Addendum No. 1

RE: Contract ID C203655

Cumberland County (W-5519)

I-95 Business/US-301 From NC-87 South To NC-59

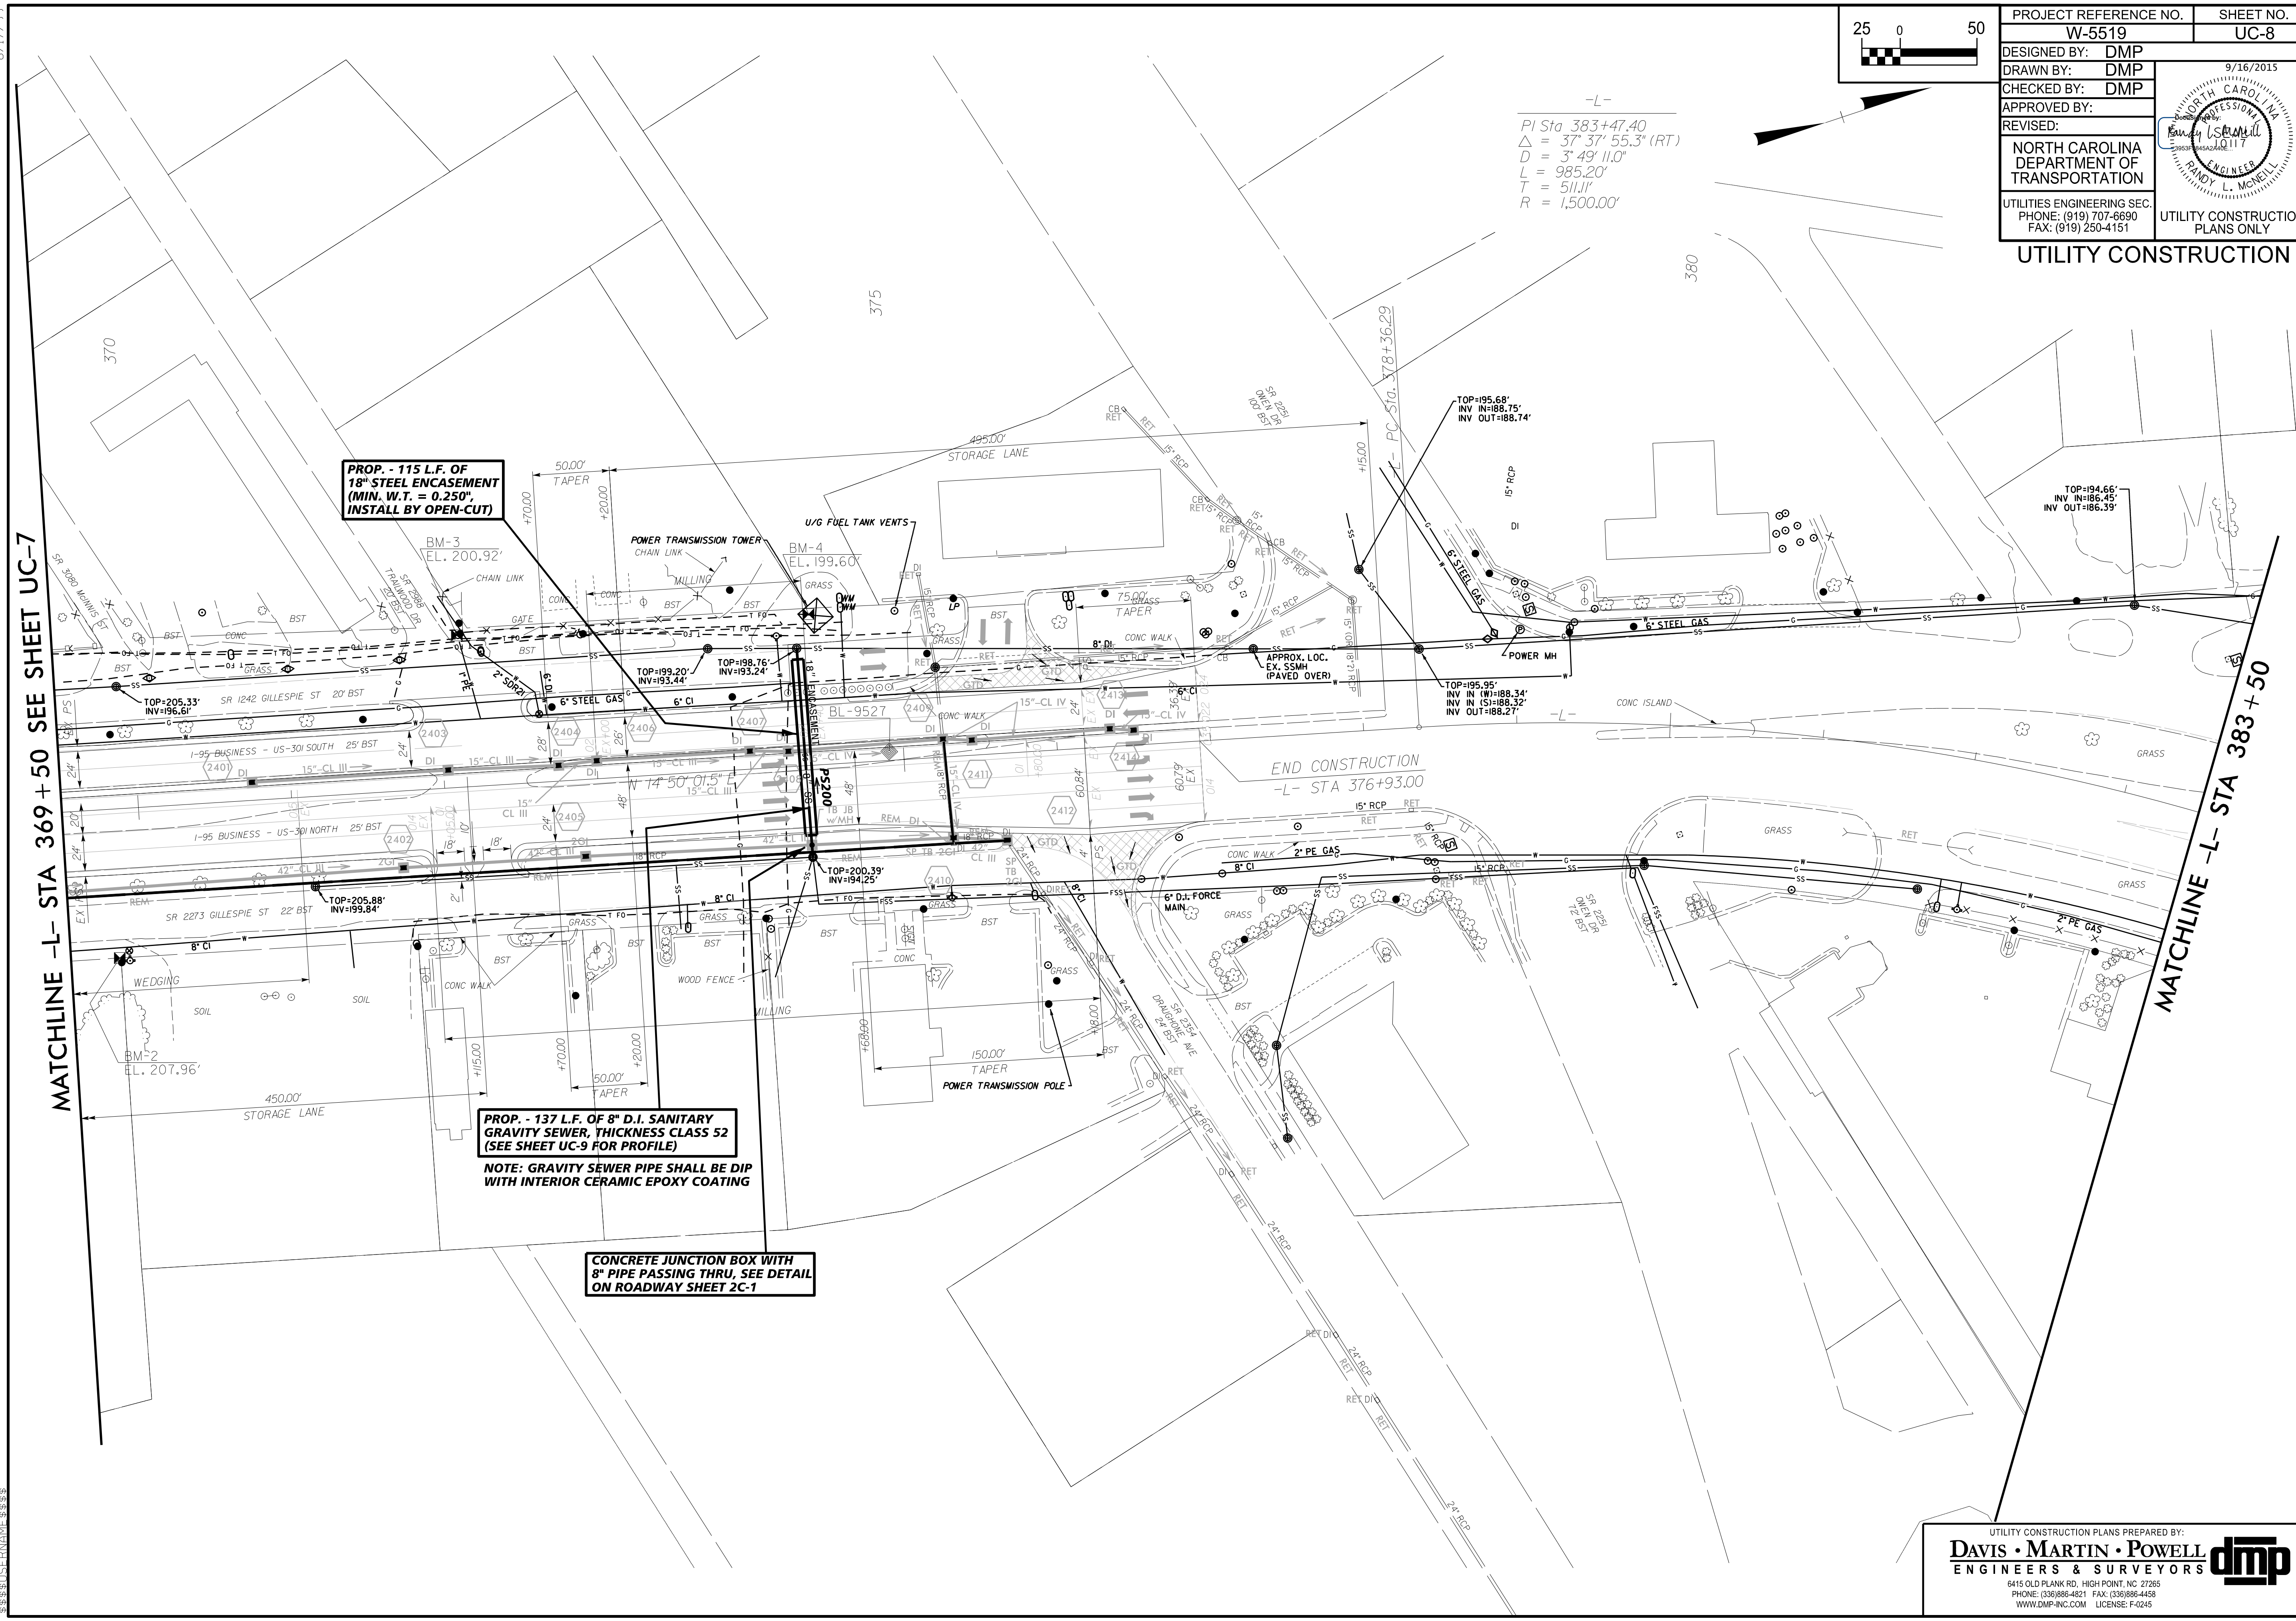
<u>Item</u>	<u>Description</u>	<u>Old Quantity</u>	<u>New Quantity</u>
099-5326600000-E-1510	16" Water Line	498 LF	505 LF
101-5691300000-E-1520	8" Sanitary Gravity Sewer	40 LF	137 LF
102-5691600000-E-1520	16" Sanitary Gravity Sewer	NEW ITEM	169 LF
104-5768000000-E-1520	Sanitary Sewer Cleanout	NEW ITEM	4 EA
107-5835800000-E-1540	18" Encasement Pipe	NEW ITEM	115 LF
108-5836200000-E-1540	30" Encasement Pipe	NEW ITEM	185 LF
